CITY OF ALBUQUERQUE

November 1, 2019

Re: Car Wash Lomas
9935 Lomas Blvd NE
Traffic Circulation Layout
Engineer's/Architect's Stamp **11-29-18** (J20D003)

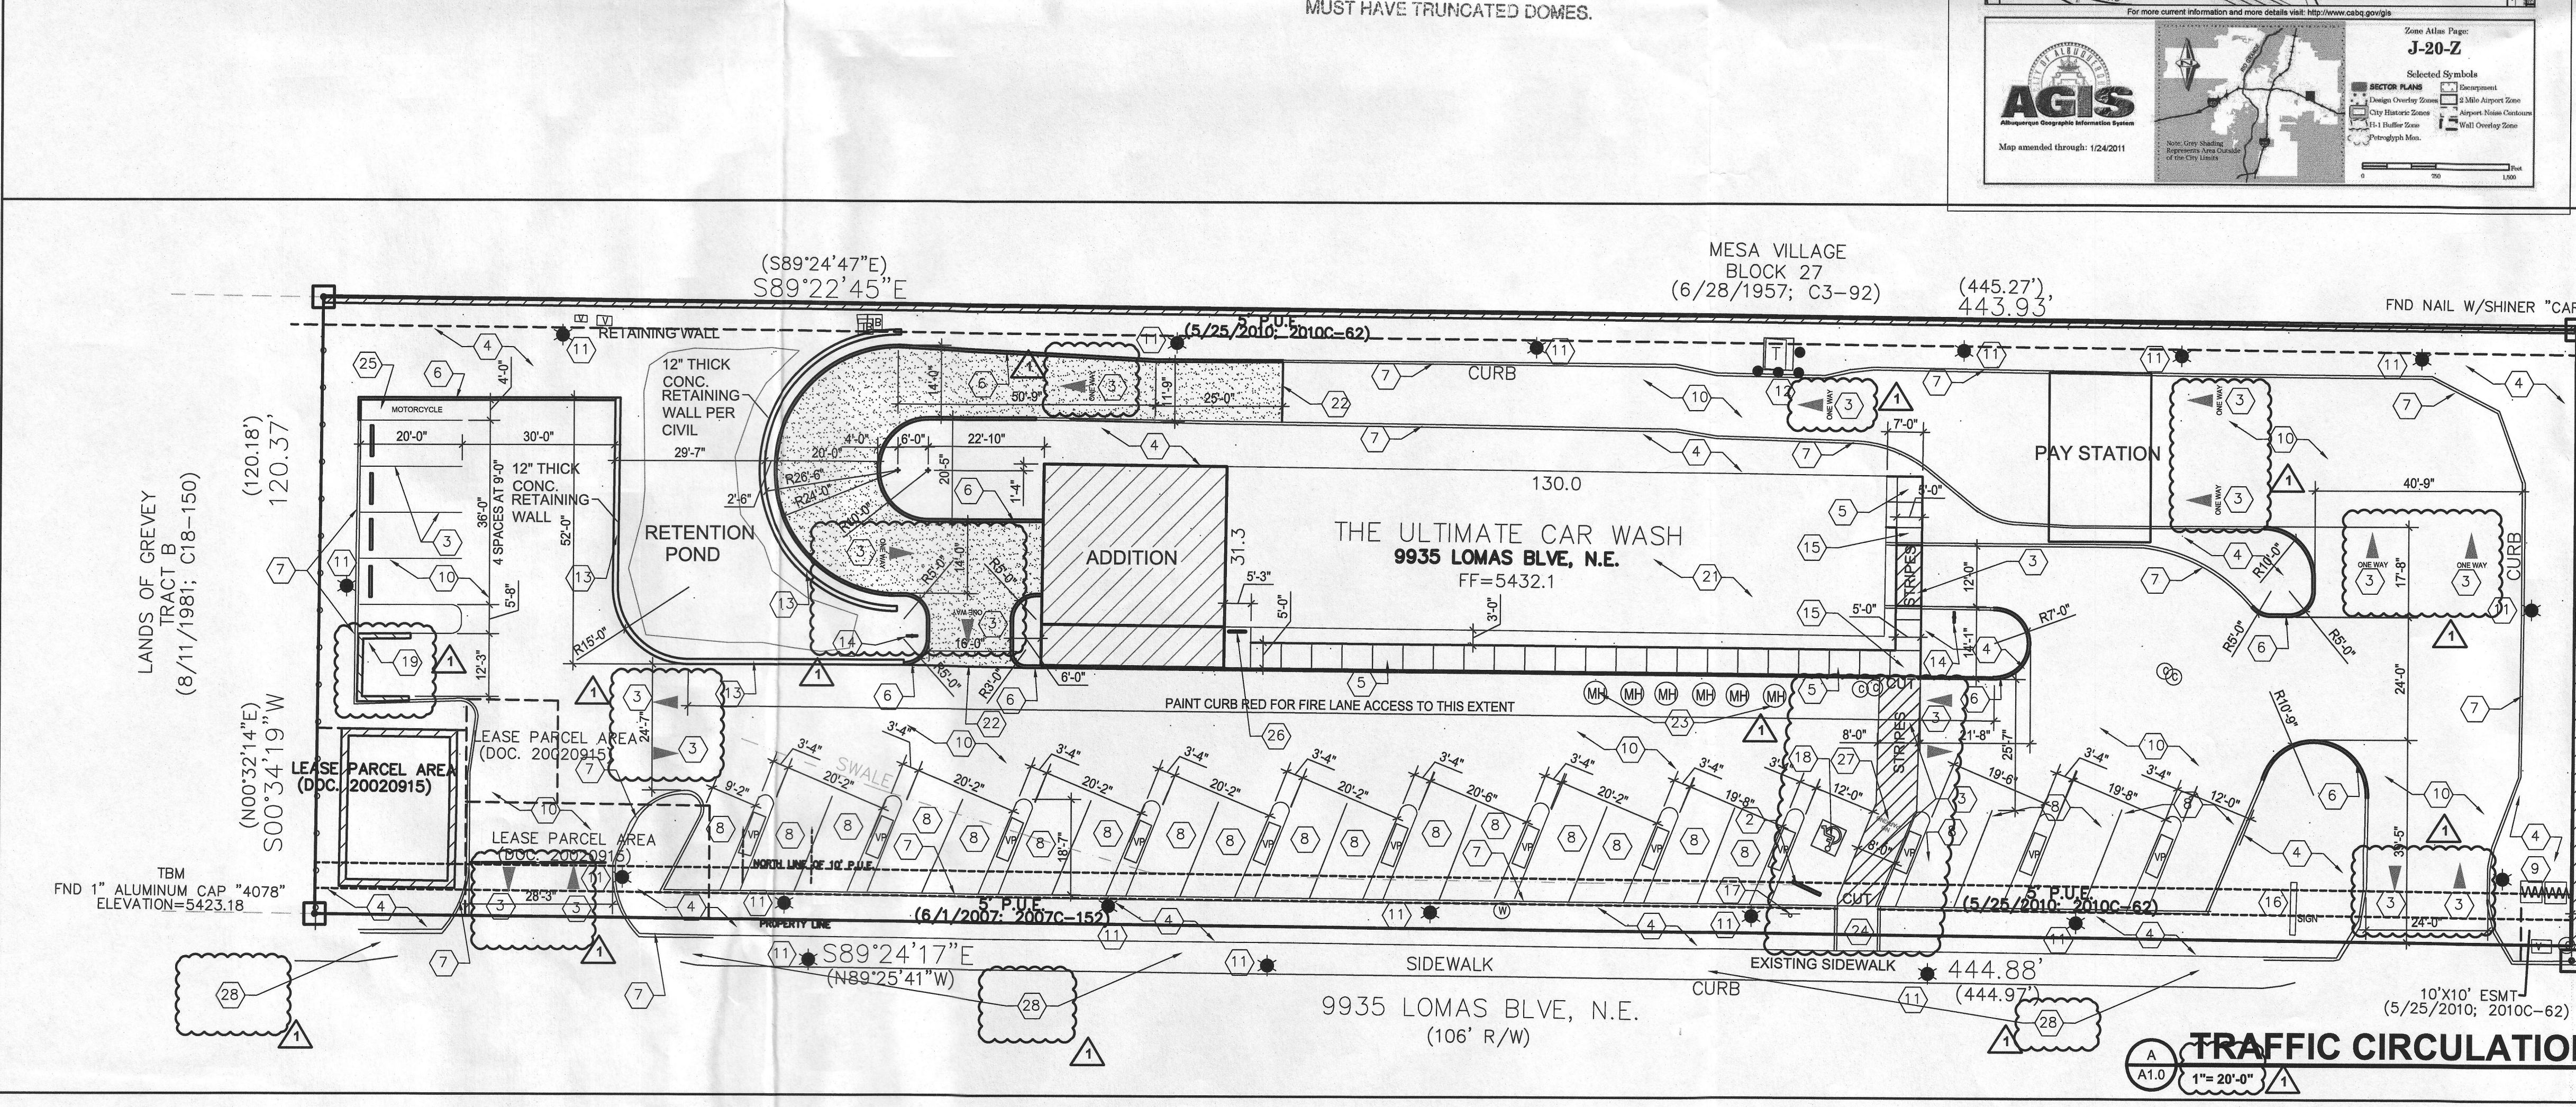
- ADA access isle needs a "NO PARKING" marking on the pavement
- Remove construction debris
- According to the DPM, the width of a drive isle should be 12 ft. wide. In the past, I have approved 10 ft. wide isles depending on the situation. Unfortunately, 8 ft. and 9 ft. wide drive isle is not workable.
